DRB CASE ACTION LOG (Preliminary/Final)

DRB Application No.: 11DRB-70215 Project # 1000572
 Project Name: THE PRESIDIO - Units 2A
 Agent: Isaacson & Arfman Phone No.: 268 8828

PLAT OF
LOT 155-A
THE PRESIDIO, UNIT 2A

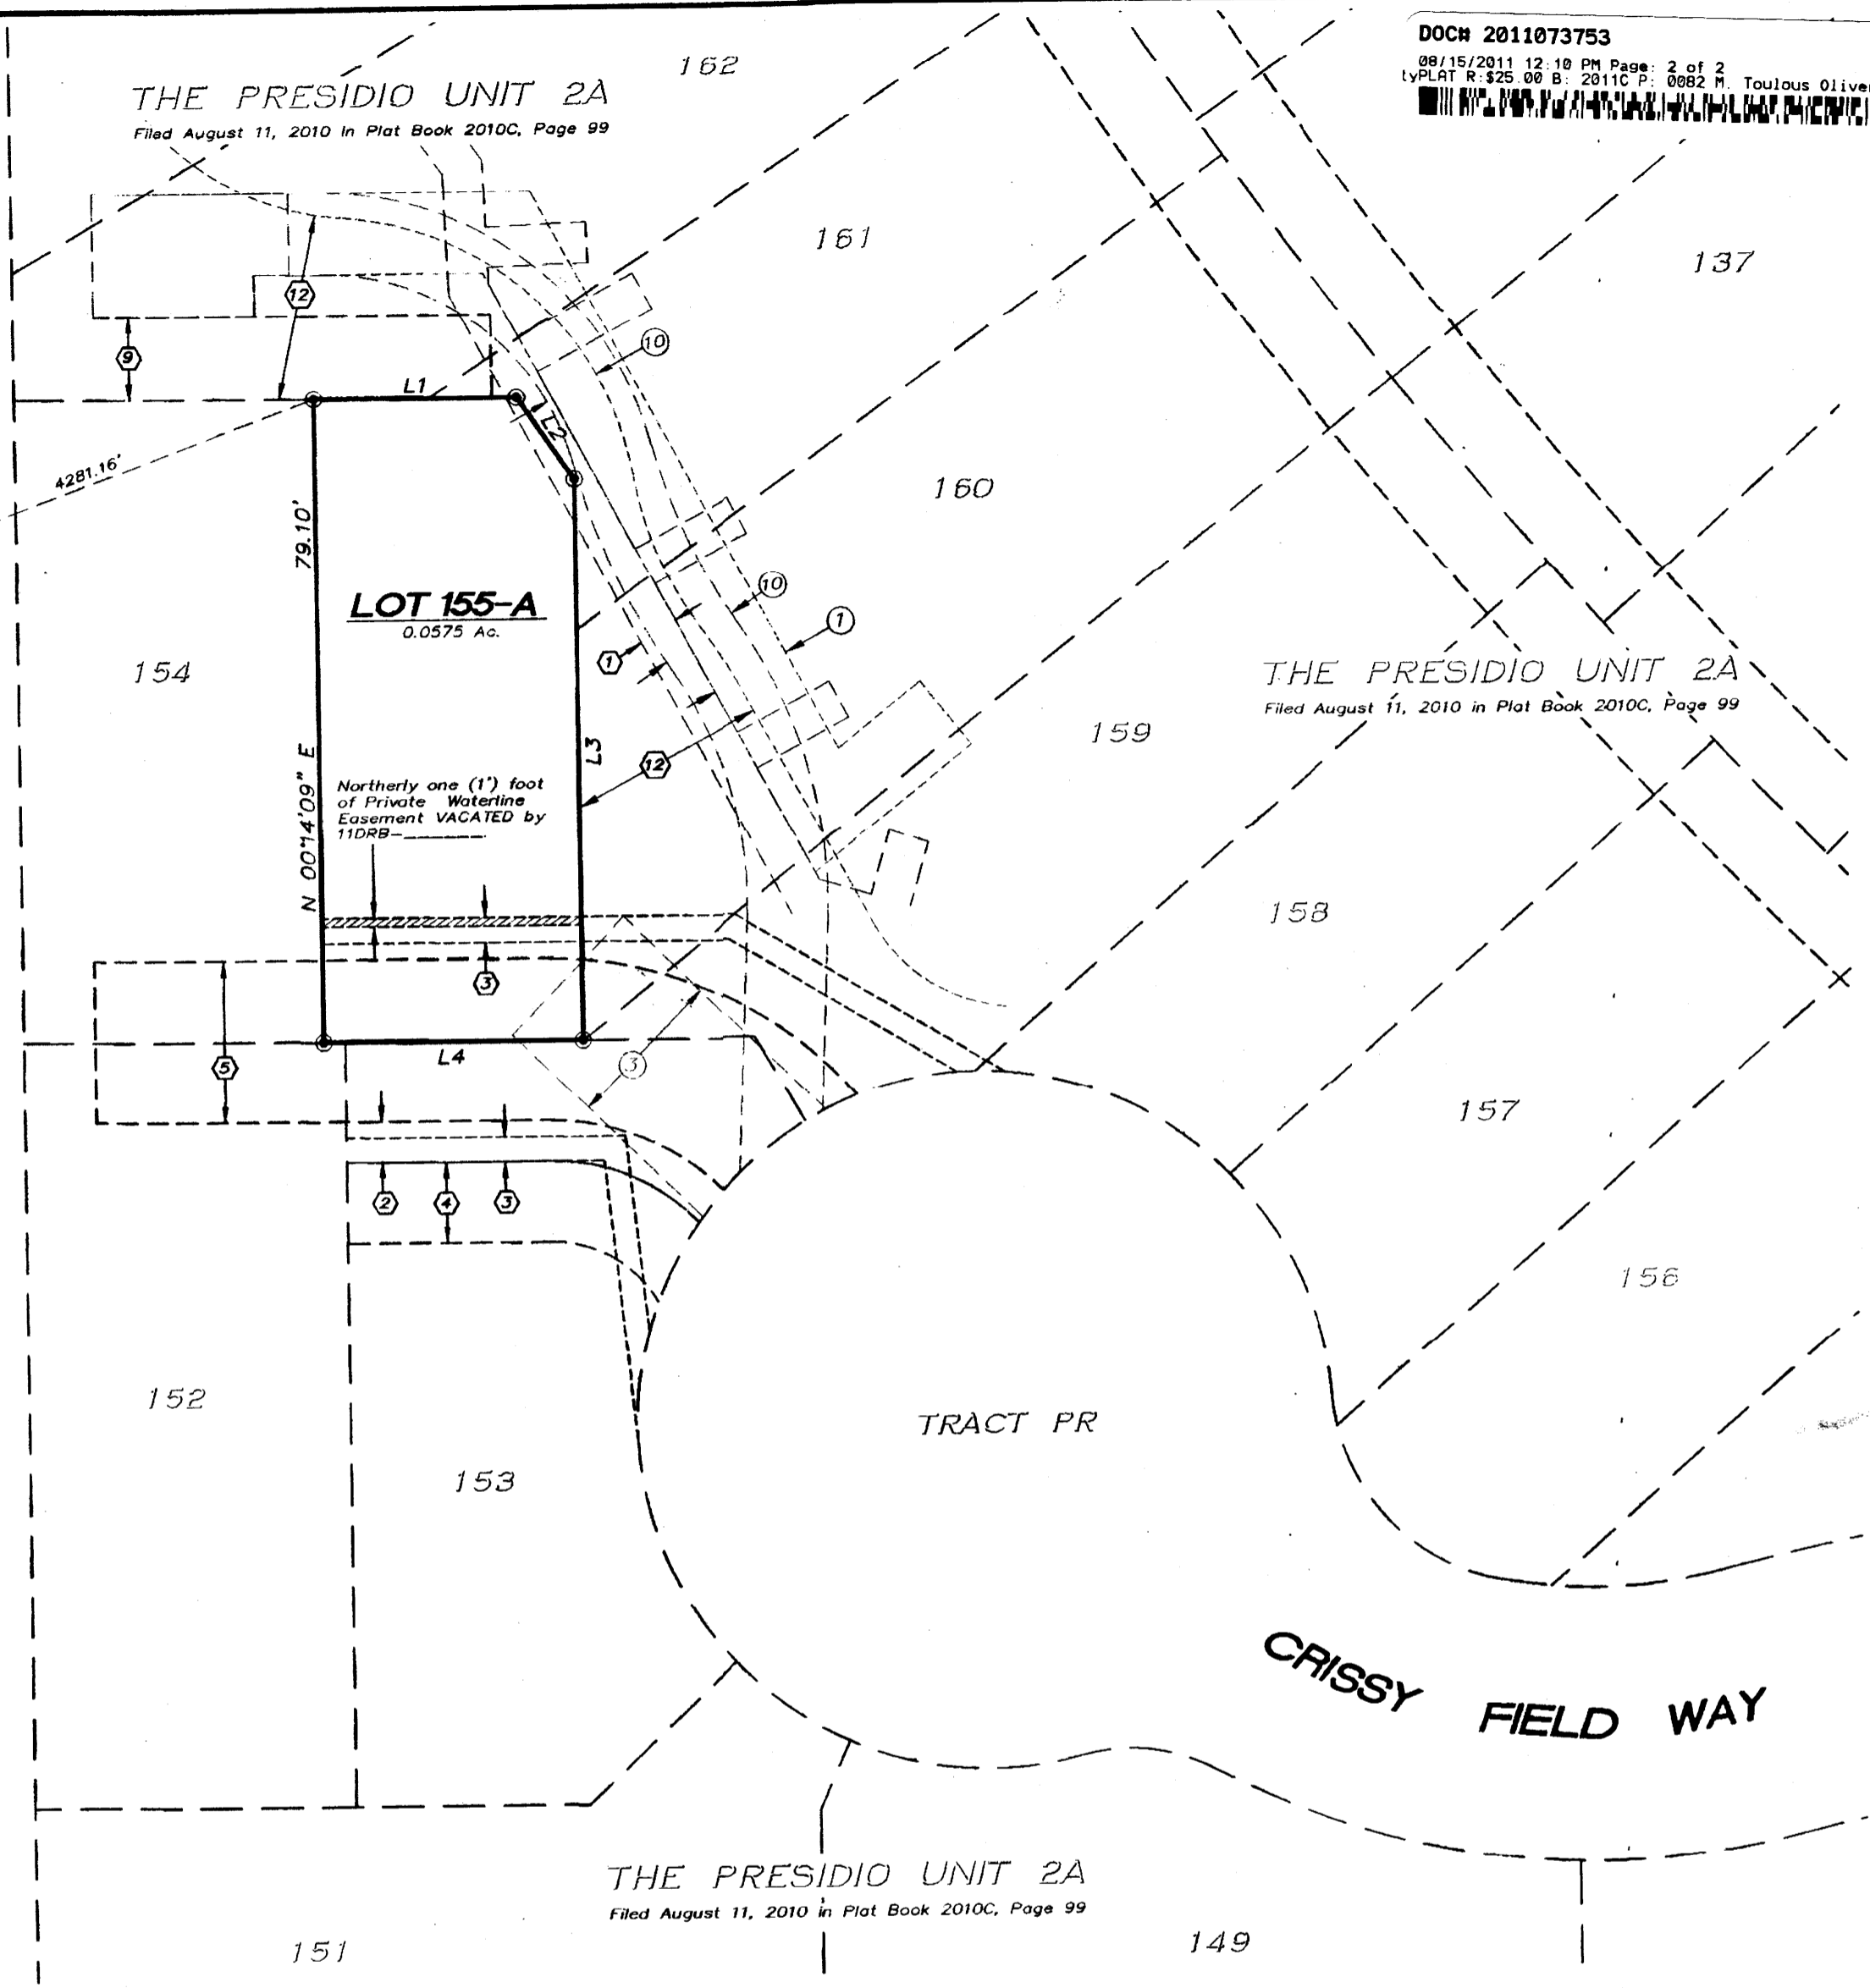
CITY ENGINEER / AMAFCA: clarify easements

PLANNING (Last to sign): OK - dxf recording info for Note 5
